NOTE: REVISION CLOUDS HIGHLIGHT THE DESIGN CHANGES AS PART OF THE RESPONSE TO THE RFI

DWG TITLE
SITE PLAN
PV LAYOUT

DWG NO.
10360452-HDR-ZZ-02-DR-E-602003

1 A1010 - PROPOSED SITE PLAN
1: 1500

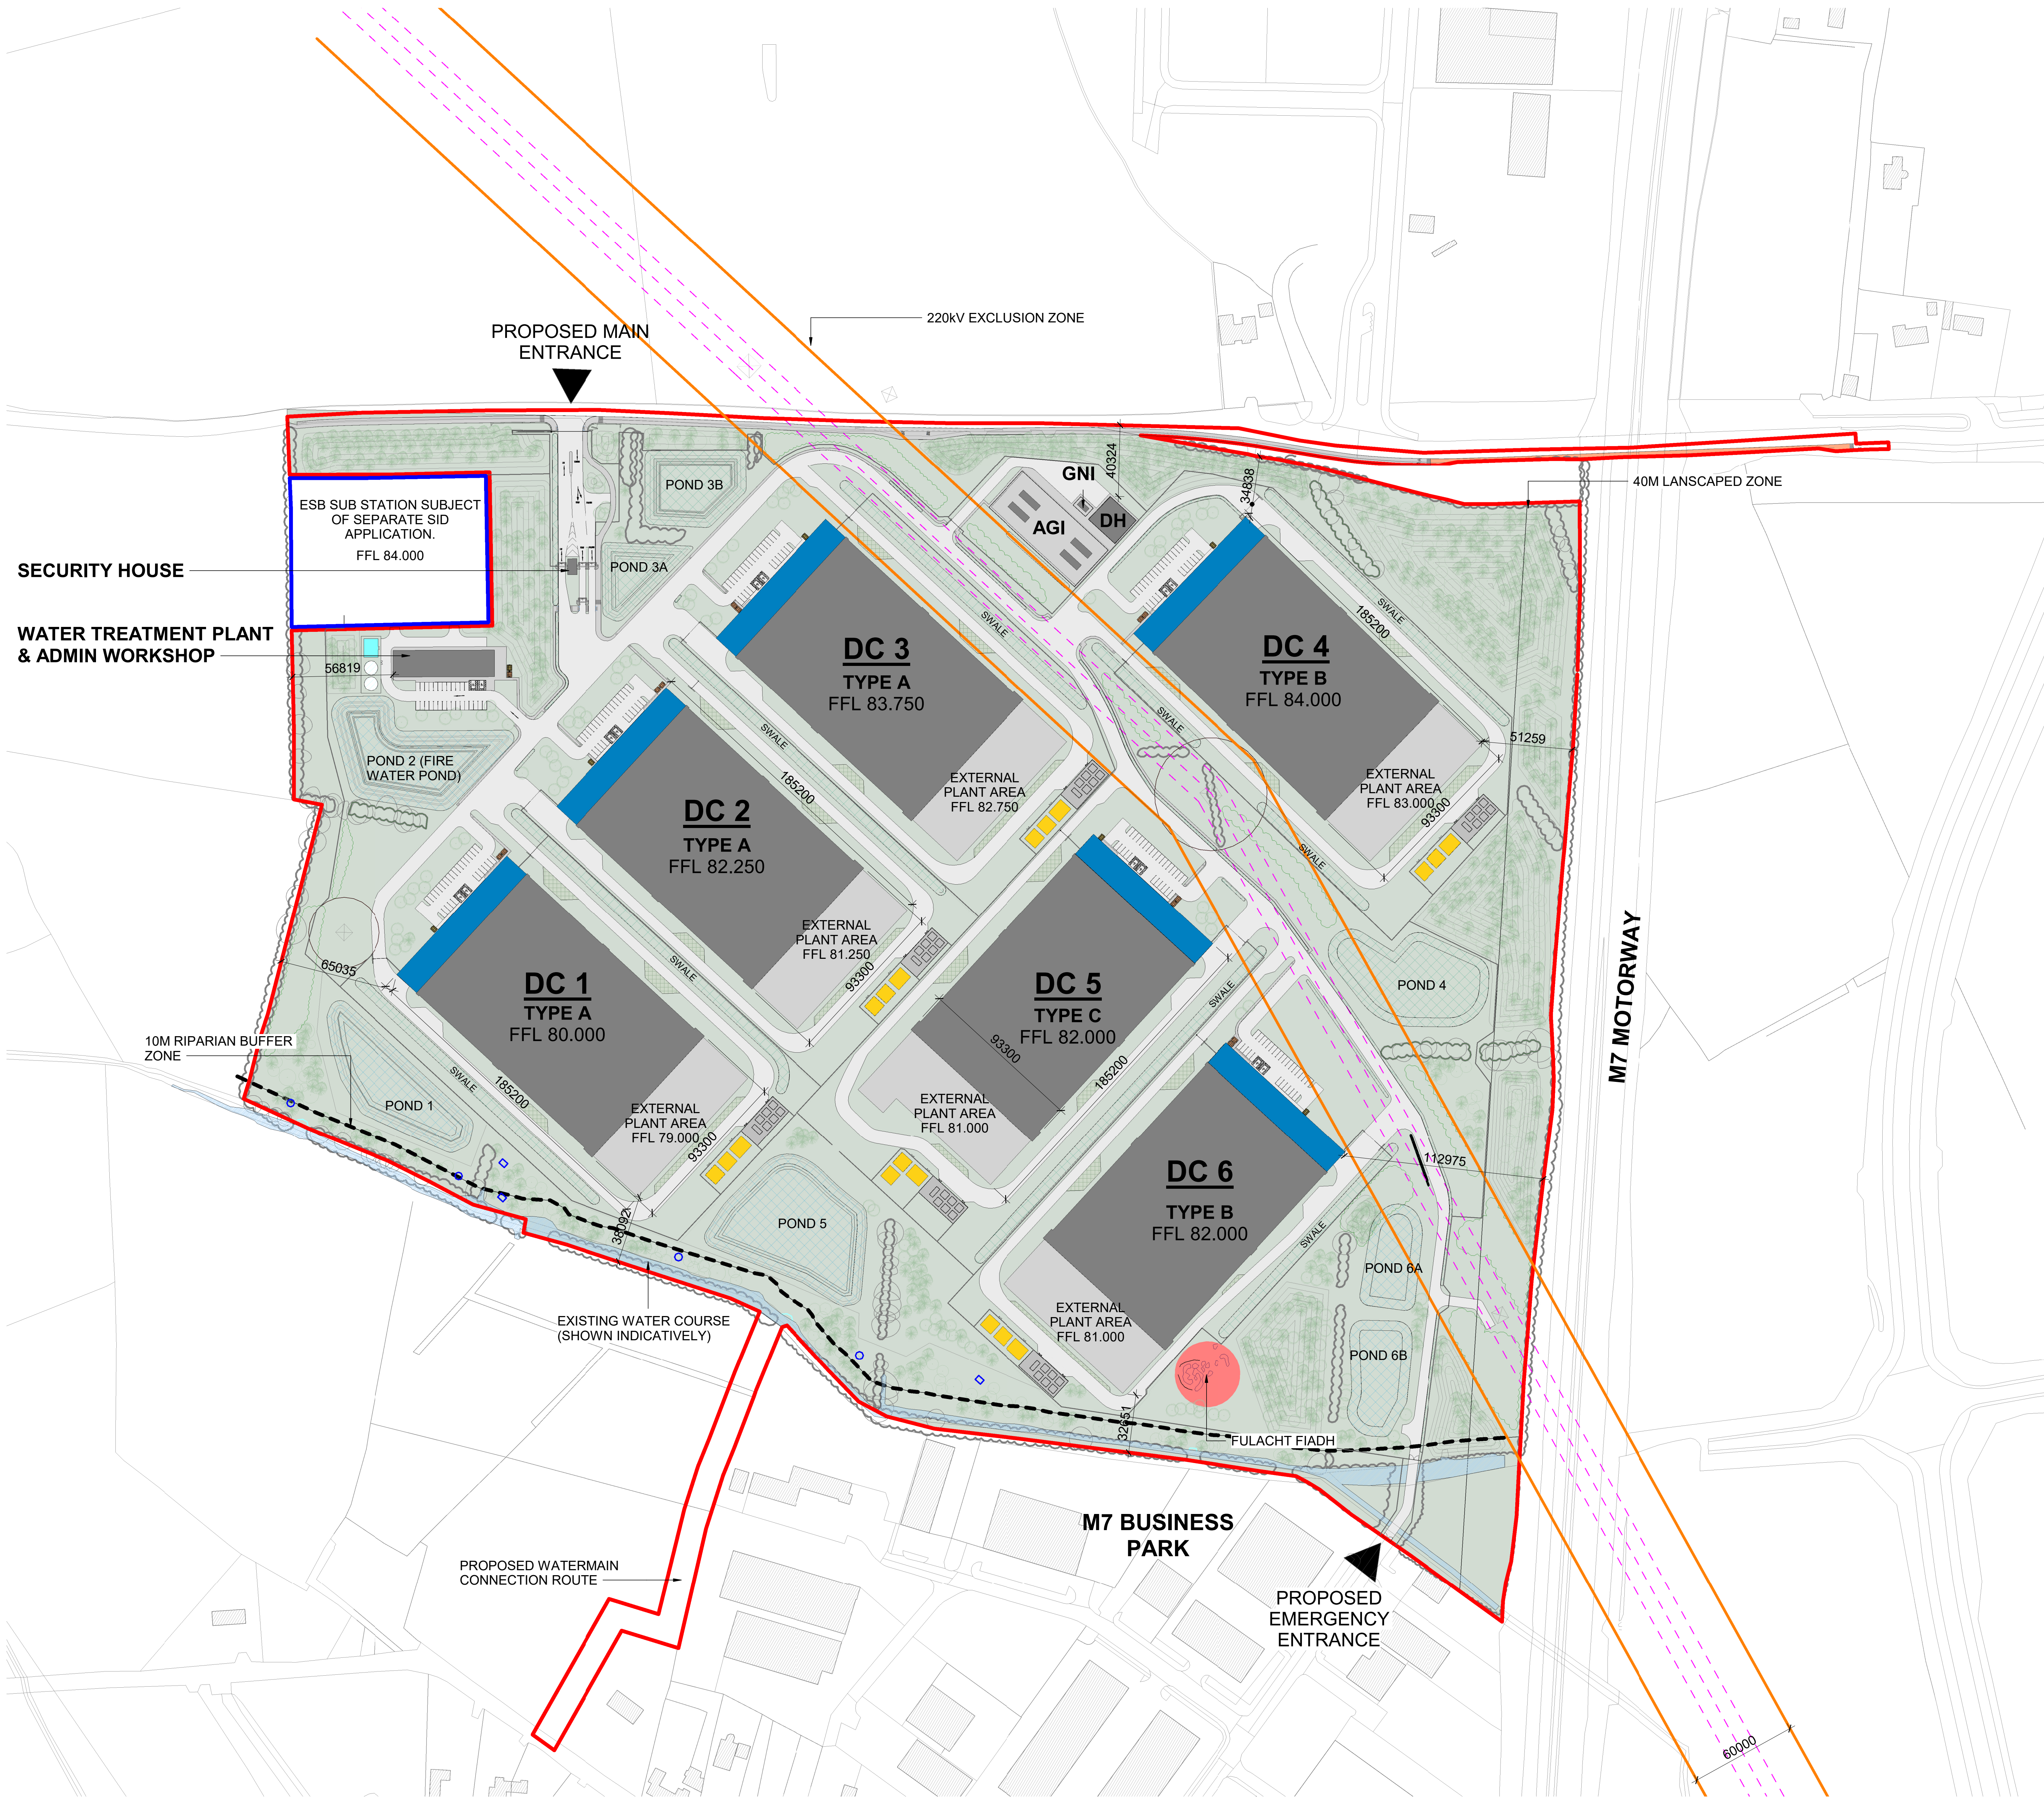
1. CCGT & Water Demand
The inclusion of Combined Cycle Gas Turbines has necessitated the addition of supporting service compounds to the masterplan, specifically at the rear of DC1-3, DC5, and DC6. For DC4, the service compound has been integrated within the building envelope. This modification has affected the placement of the Sprinkler Tank and Fuel Compounds.

Following additional archaeological survey studies, an additional Fulacht Fiadh was identified at the southern corner of the previously designated location of DC4. As a result, the size of DC4 has been significantly reduced in size and shape, leading to necessary adaptations to the perimeter road, attenuation pond, fence line, and the main access road running through the site.

Additionally, the cycle and pedestrian lane along the R409 have been revised to pass behind the proposed bus stop. Additionally, the alignment of the cycle and pedestrian lane has been set back from the main entrance and egress of the site, enhancing visibility for passing vehicles intending to enter.
